ASSESSMENT REPORT

ORICA SOUTHLANDS PROJECT – BOTANY INDUSTRIAL ESTATE MP 06_0191 MOD 3

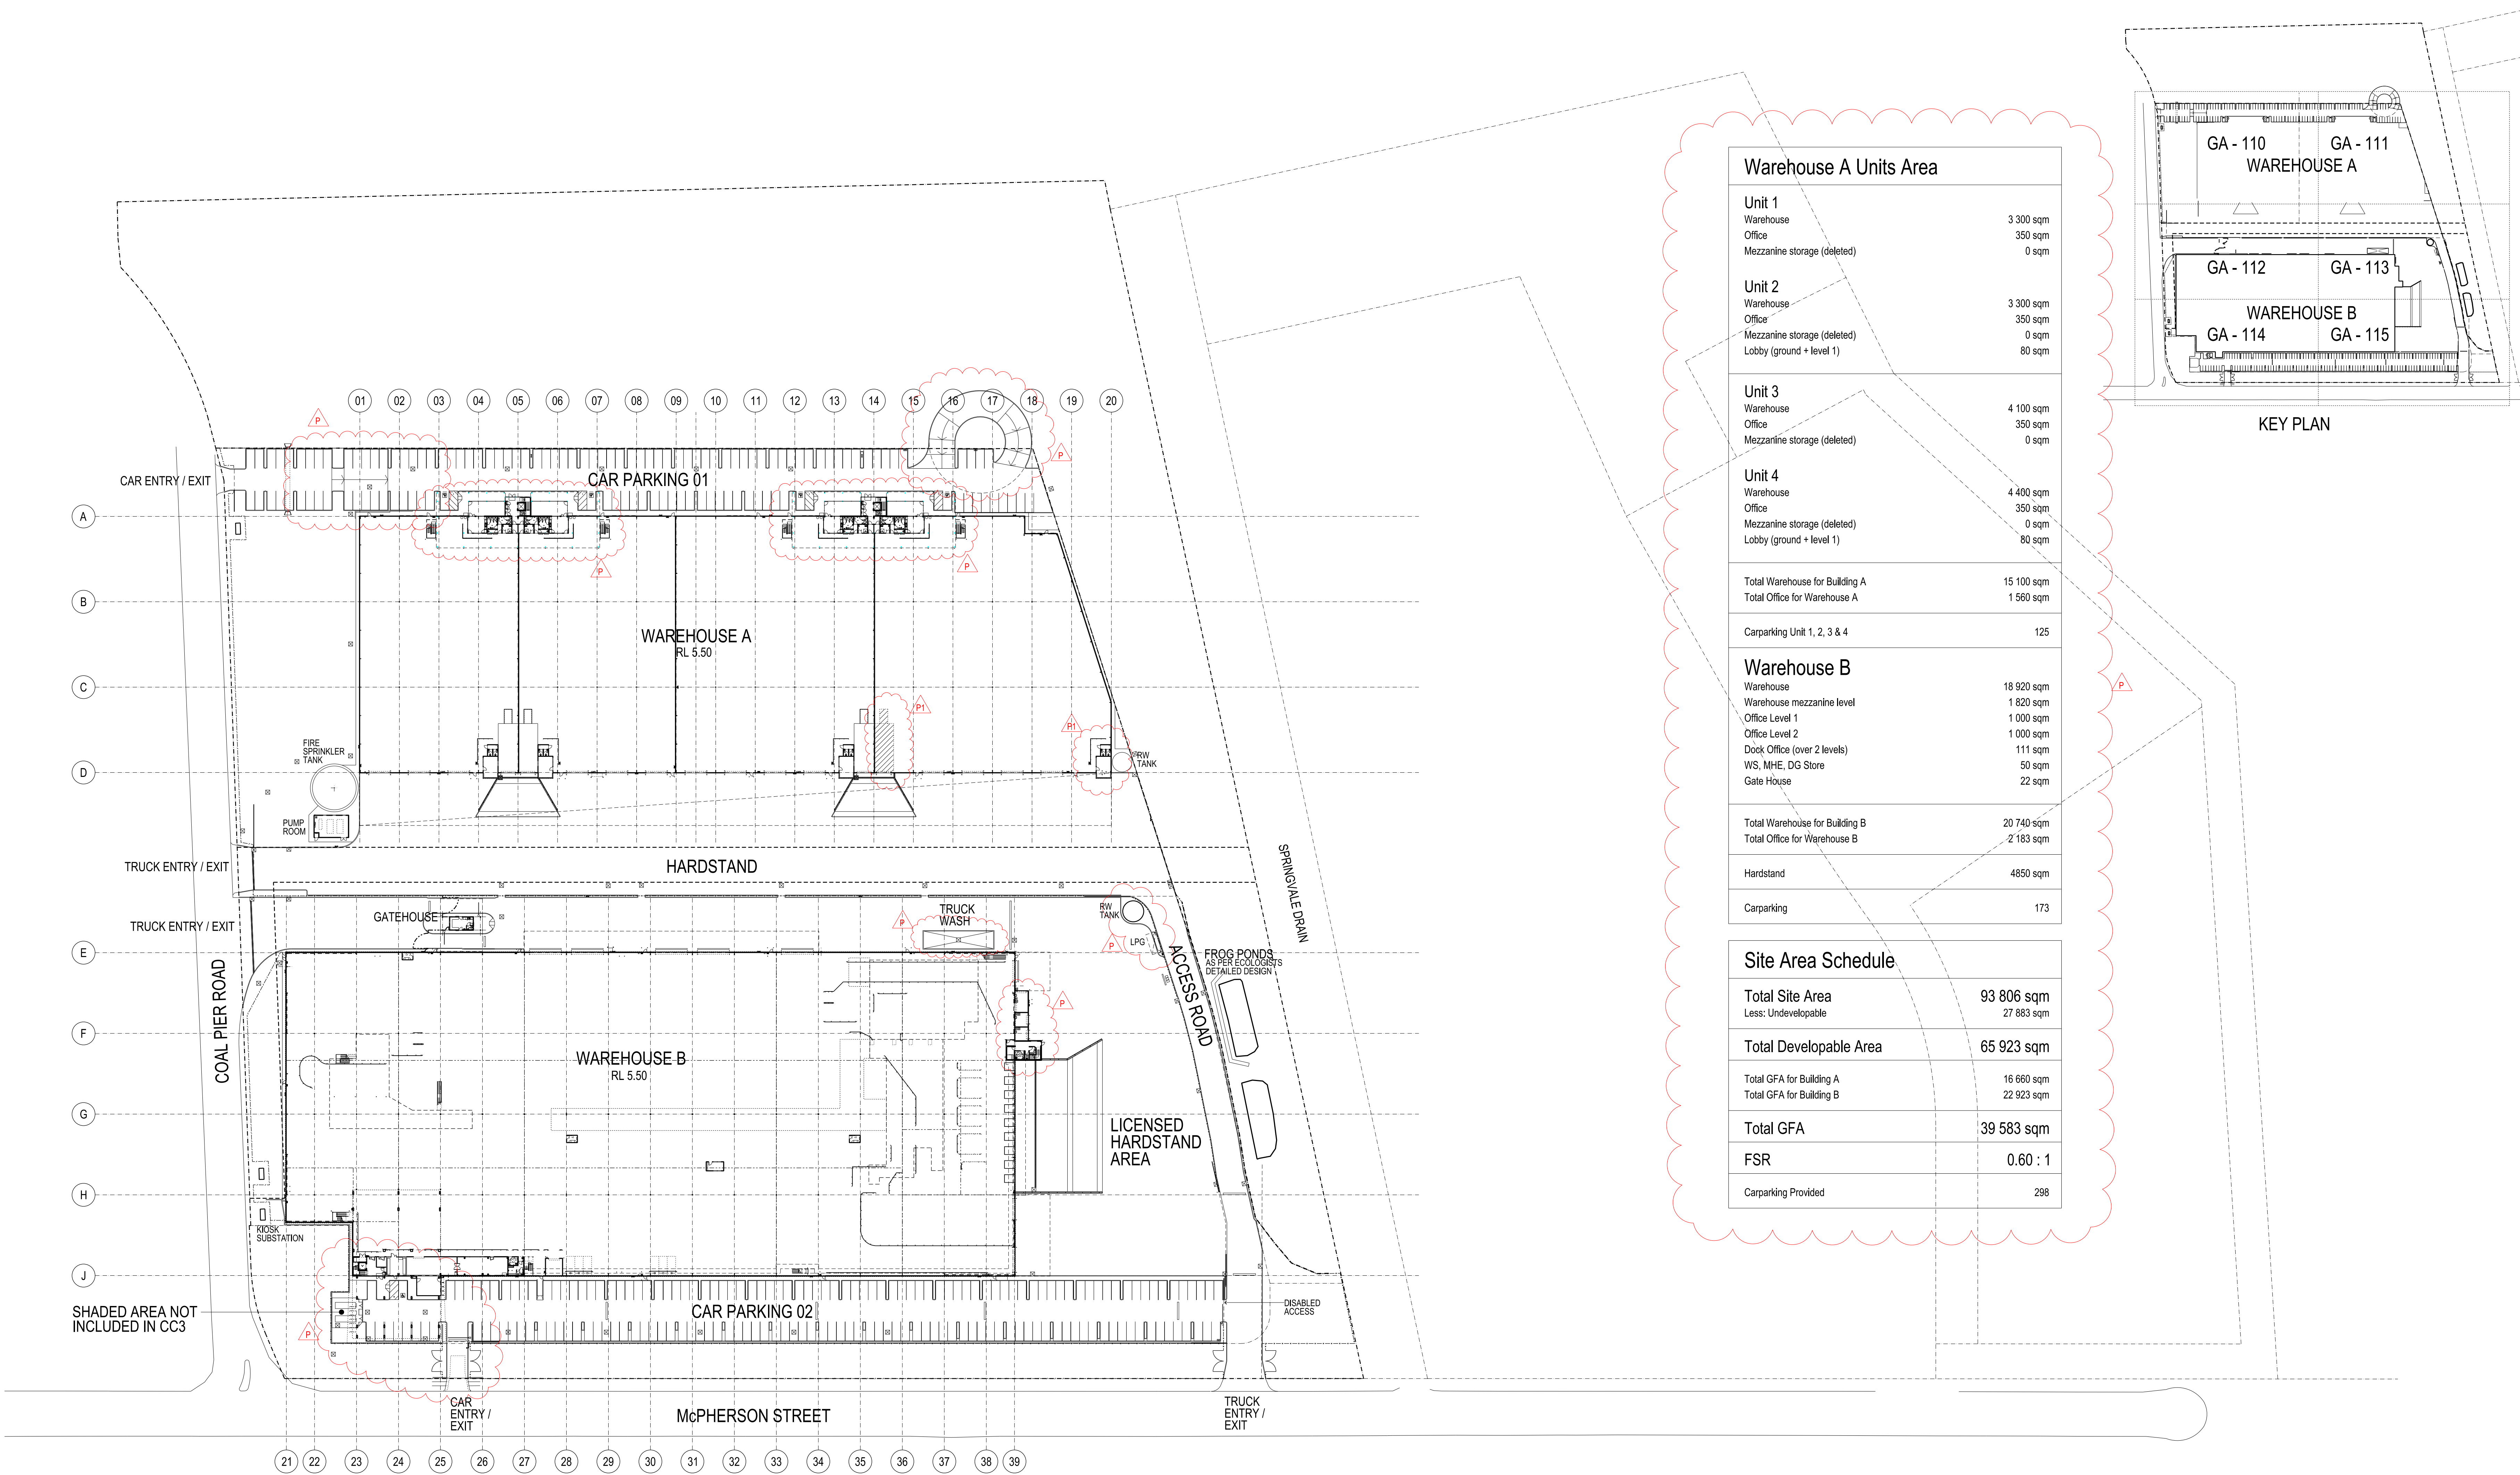
- the truck turning circle design;
- whether the proposed turning circle would impact the flood detention basin;
- clarification regarding the proposed warehouse floor space; and
- landscaping of the car park area.

- a revised Statement of Environmental Effects (SEE) with updated architectural and civil drawings including clarification of floor space and the design of the turning circle;
- advice that it fully intends to comply with an existing condition requiring a final flood impact validation assessment, based on the final approved works; and it would amend the Section 88B/E instrument to ensure only Botany Bay Council has authority to release, vary or modify the relevant easement is consistent with the conditions of the approval;
- an additional flood impact assessment report by Aurecon Australasia Pty Ltd (dated 25 August); and
- an updated flood impact assessment from Aurecon Australasia Pty Ltd (dated 29 January 2016) and a peer review of the flood impact assessment by WMAwater dated 3 February 2016.
